Lancashire Gardens Trust
Conservation & Planning Group

Your ref: 3/2022/0988

Planning Application No: 3/2022/0988;
Proposed erection of one private dwelling with landscaping and demolition of equestrian development; Adjacent to Further Lane and Woodfold Park, Mellor, BB2 7QA. GT Ref: E22/1416.

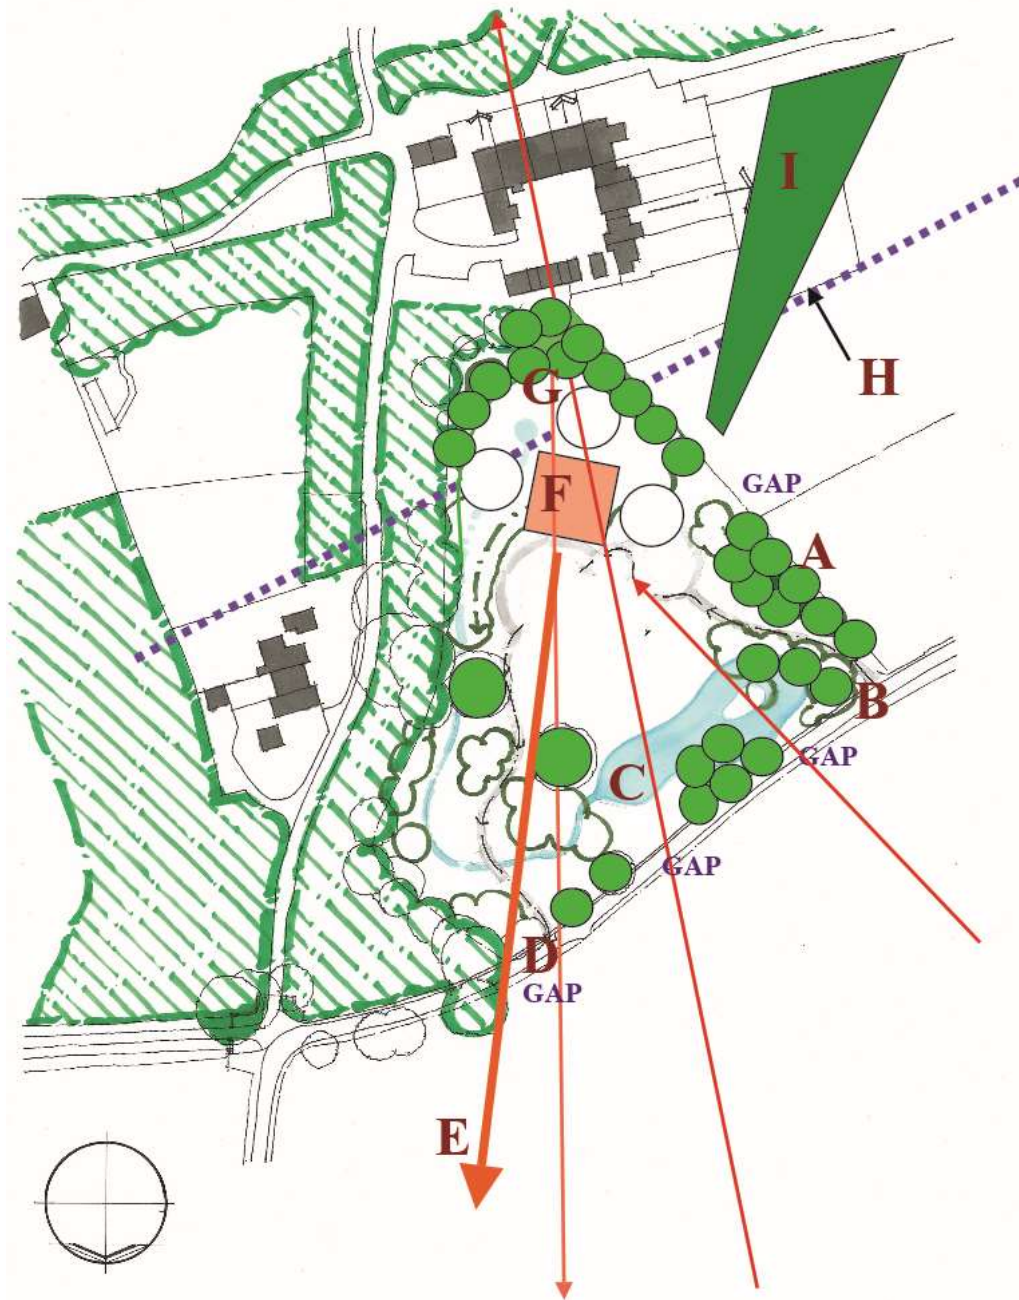
This application includes a Character Study which is intended to address heritage matters. However, this long document makes selective use of facts and descriptions and contains erroneous and unproven historic conclusions. For example, reference is made to Shorrock 'Hall' previously occupying the position of Huntsman's Cottages. There is no map evidence of any named Hall or principal building in this location which is more likely that of a hamlet or cluster of agricultural buildings. As a result of discussions with local residents we understand there is evidence that Further Lane was diverted northwards to its present line at a date following Yates Map of 1786, and our review of map evidence suggests that this is a tenable premise. The suggestion of an axial 'avenue' described in the Character Study crossing the application site towards Shorrocks is most likely the former line of Further Lane, relict features of which are indicated on the 1840s OS map. Therefore this route is rather the earlier alignment prior to its diversion as part of the 1790s emparkment. The narrative in the Character Study places much weight on these features in order to support the concept and placing of a new dwelling on the proposed site, however these arguments are questionable and should not to be relied upon.
